1 Barrack Lane, 81-83 George Street Build-to-Rent Development (SSD-79439459): Response to Submissions – Heritage

This letter has been prepared to respond to the RTS themes broadly and specifically submitted by agencies and City of Parramatta Council as outlined in the key issues letter by the Department of Planning, Housing and Infrastructure, dated 24 December 2025. It addresses both built heritage and archaeological issues.

REV. **B** DRAWING NO. **DA* 100A**

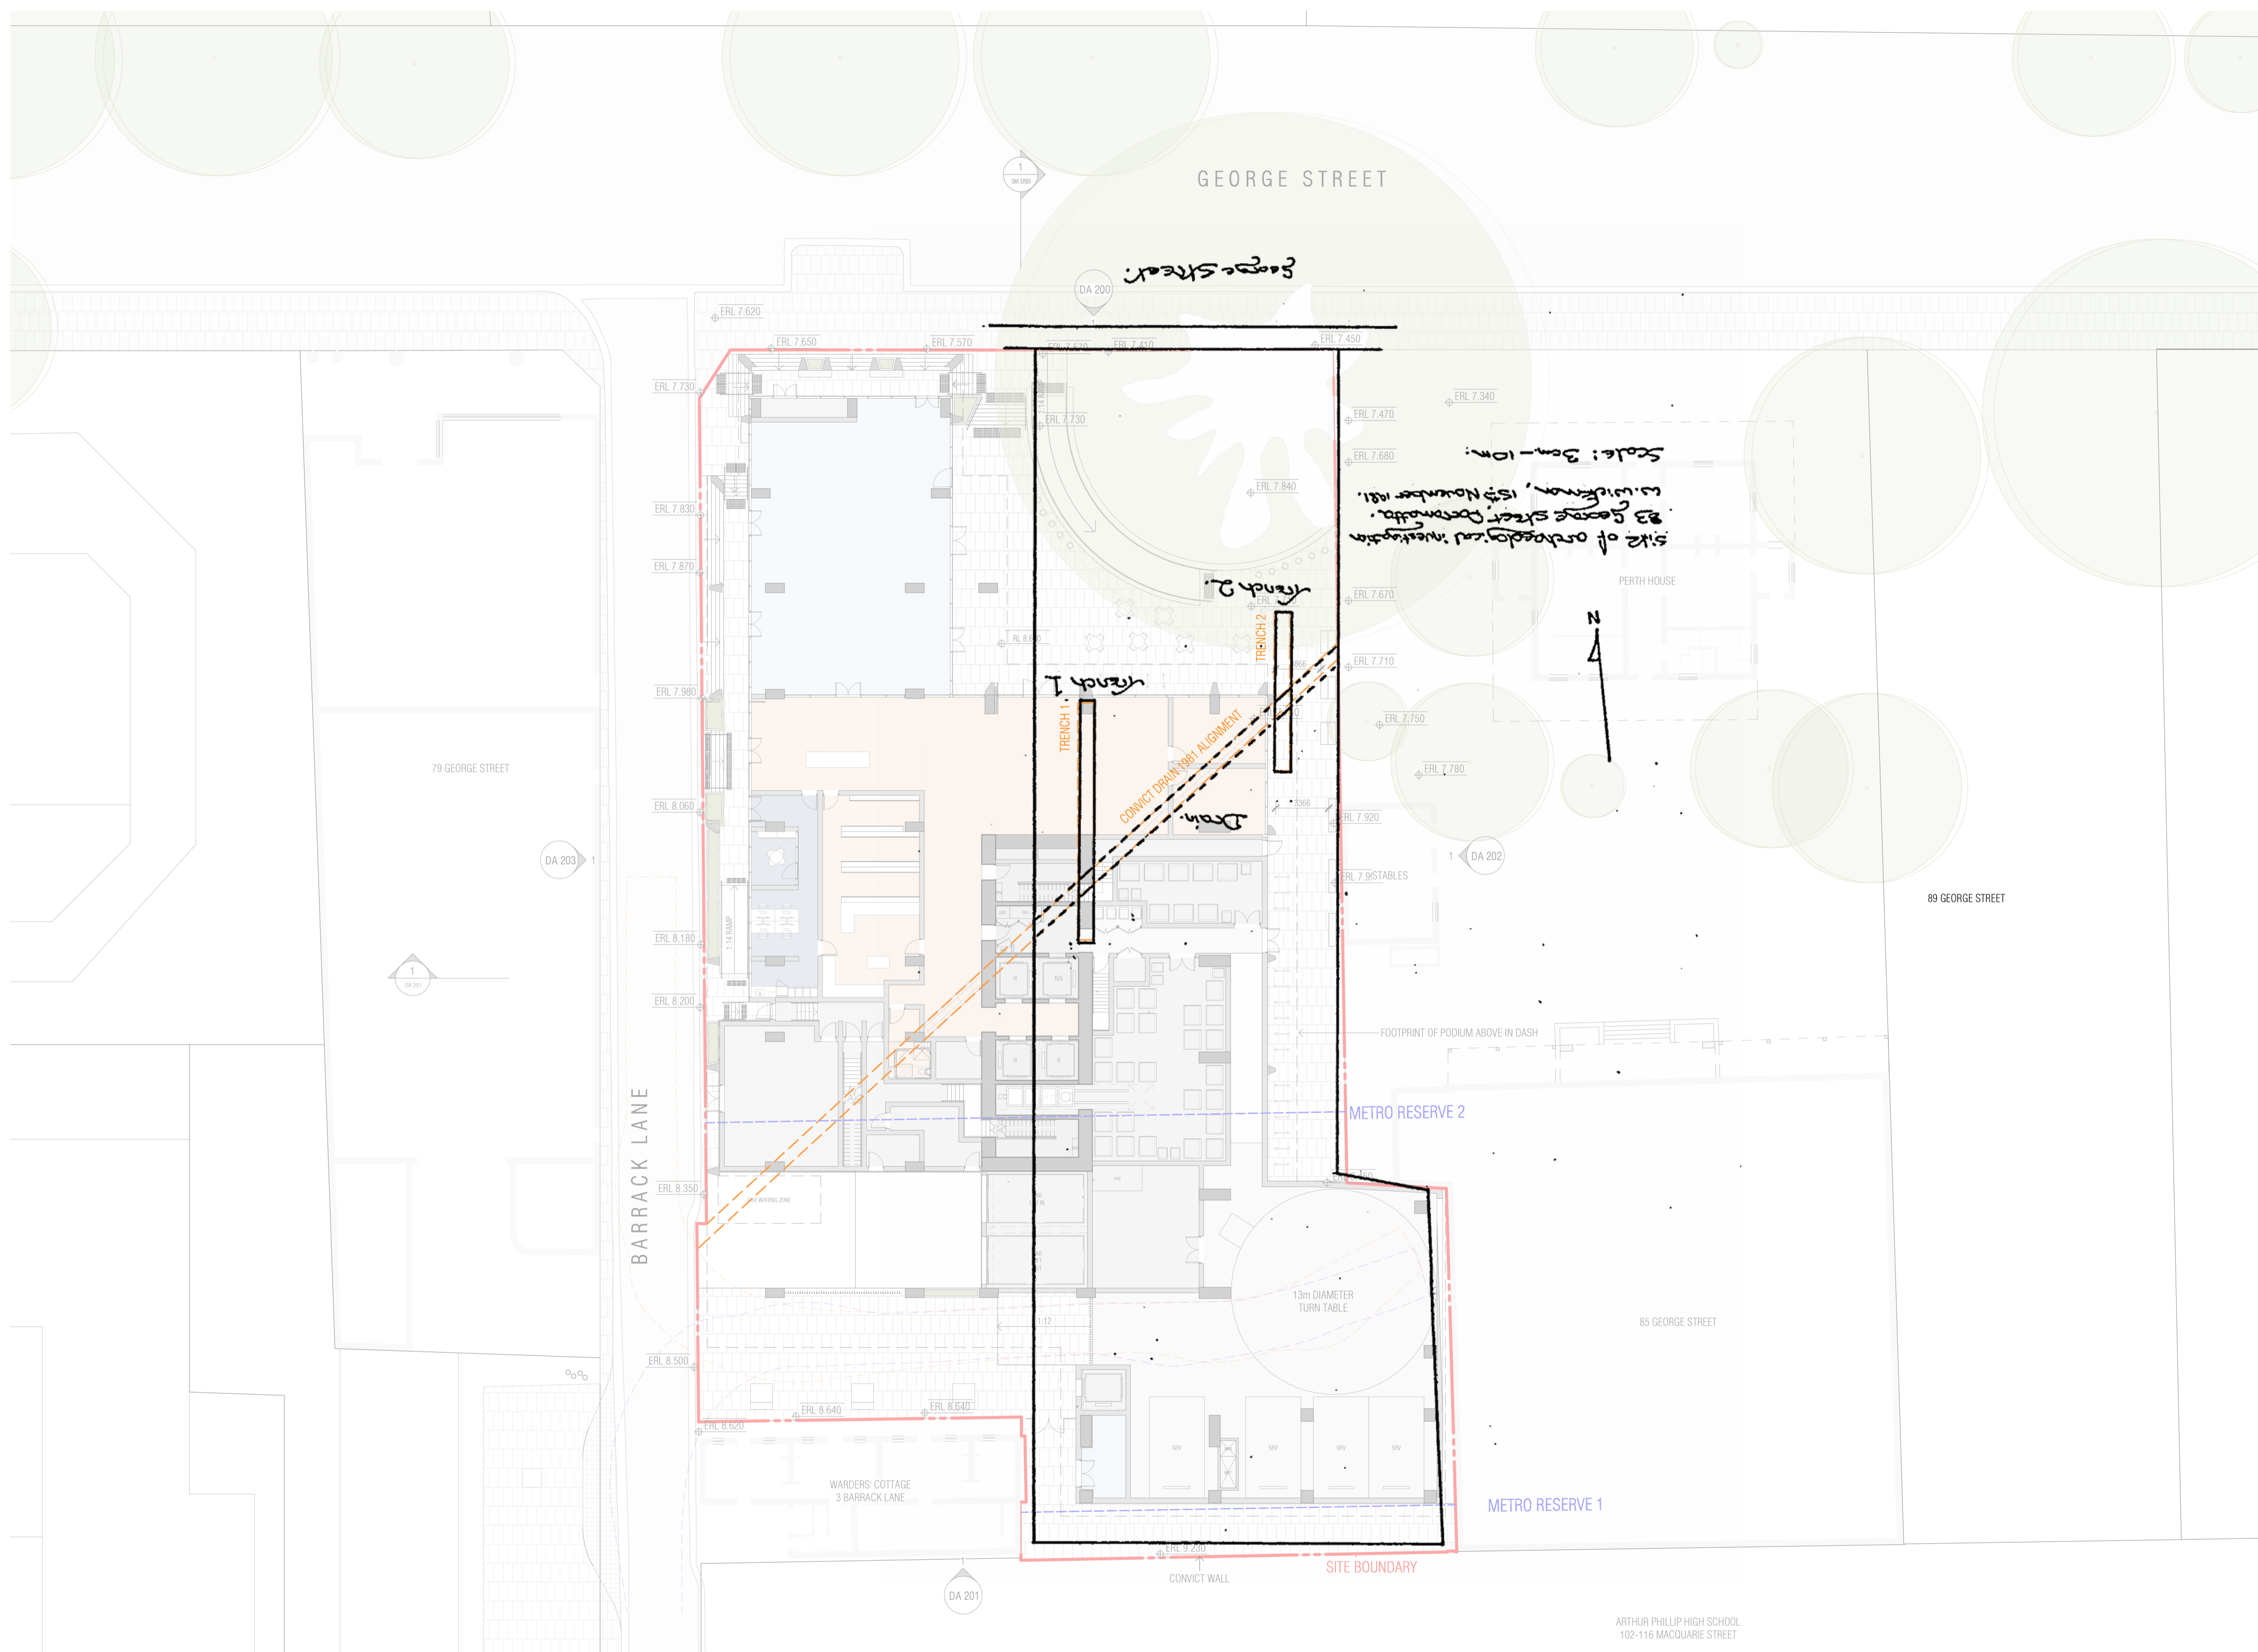
HNSW-13	Following review of the EIS, it appears that the mapped alignment of the Convict Drain shown in the Architectural Plans and Structural Design Report in Appendices E and AR of the EIS are based on the alignment provided in historical plans (shown as the 1844 plan alignment in Figure 34 of the HAIA), while the results of previous archaeological investigations suggest that its actual alignment may be further to the south, in an area which may be impacted by the proposed lift well.	The results of the proposed test excavation will better identify the location and integrity of the Convict Drain. The plan available from the previous investigations carried out in the 1980s is of poor quality and the intention of the current program is to better ground-truth these remains. An updated plan with overlay of the 1980s alignment has been prepared by FK with excerpt included below.

Item Ref.	Summary of Matters Raised	Response
		 DA 100a Ground Floor Plan mapping location of the convict drain as documented in 1981
HNSW-14	Further design development should ensure that the results of the archaeological research and test excavations (when available) are considered when finalising areas which require deeper excavation. We note that the Structural Design Report makes provision for review of the structural design to accommodate any findings of the archaeological investigations.	Once test excavation is undertaken, the project archaeologist will work with the design team to ensure that the results of the test excavation are considered through design development.
HNSW-15	Following completion of test excavations, detailed advice will be provided to Planning regarding the adequacy of the	Following completion of the test excavations an Interim Test Excavation Report will be completed and submitted for consideration, which will address the matters listed.
